### ISH 3\_22 March PT4

Okay. Welcome back, everyone. It's 345, so we'll resume the hearing, please. Is everyone logged back in that we know of from. From the case team? Yeah. Fantastic. Thank you. Okay, we'll jump straight on to agenda item number seven, which is in relation to water quality and resources. Um, and the first question is in relation to the change request in relation to the onshore substation.

And there is another similar question on that in relation to item Agenda number three and this subject. So we'll deal with those together. So first off, for the benefit of everyone, please can the applicant just provide a brief overview of the change request submitted in relation to the drainage at the onshore substation? Please.

Figure 9-10: 1 in 100 year plus 40% for climate change extent in comparison with Option 2 layout using net rainfall hyetograph

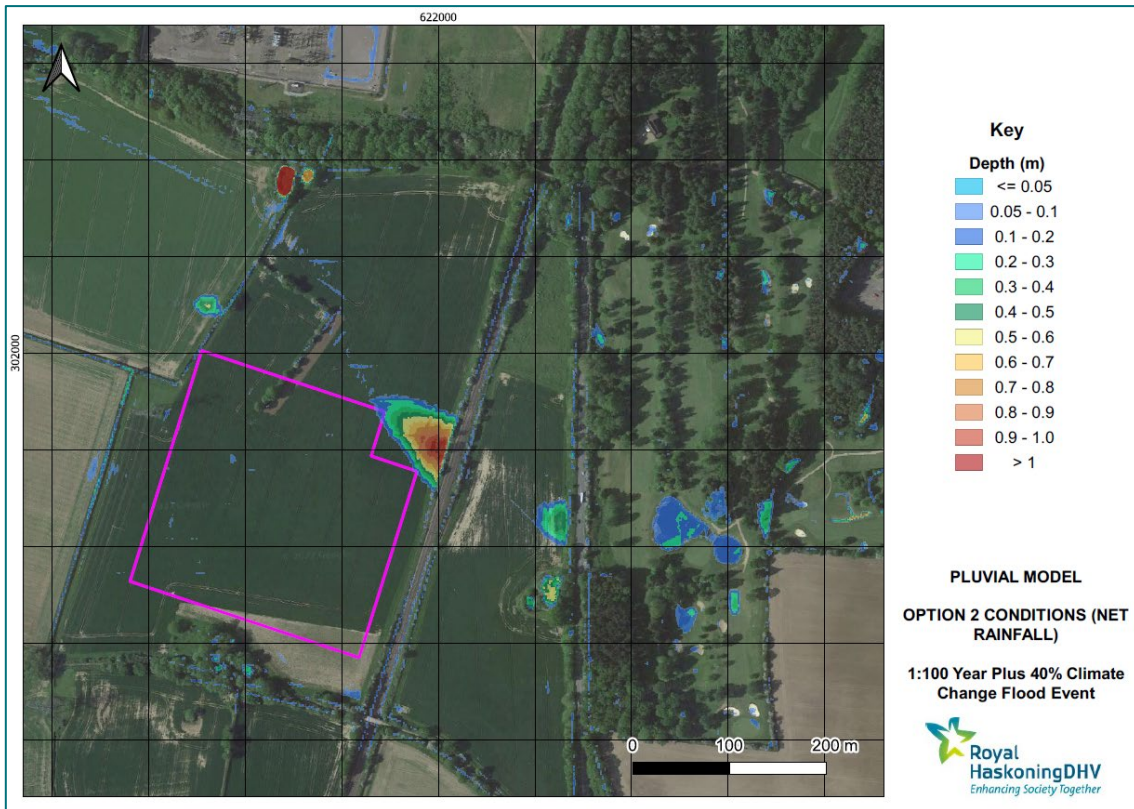
Okay. The onshore substation hydraulic modelling reports, which is rep 2-055, shows that option two, which is the proposed solution in this case, overlaps with the baseline surface water flood extent in the 1 in 100 year plus 40% for climate change and 45% additions for climate change events. The question which comes to mind is given on the figures, particularly 911, 917 and 920 of the onshore hydraulic modelling report show a small interaction sort of at the top north east corner between the base of the proposed base of the substation and the surface water extent.

Why that area can't be avoided altogether either by reducing the size of the the the base or by slightly repositioning the base a few meters maybe to the south.

Helena works on behalf of the applicant. At the present time, it shows the two options for the substation orientations that might be in there. It is taking deliberately taking a conservative approach to ensure that any interaction with the flood risk has been addressed or considered. Obviously, during the detailed design there may be options to alter that slightly, but at the present time it's taken the Conservative approach to make sure that we've considered the worst case flood risk that we can in that location.

Julian Boswell for the applicant. Just to emphasise an enormous amount of iterations and time and effort has gone in to get to where we are. If we could have straightforwardly achieved that result, we would have done.

Yes, we are. Sorry, Sarah. Yes, we are, sir.
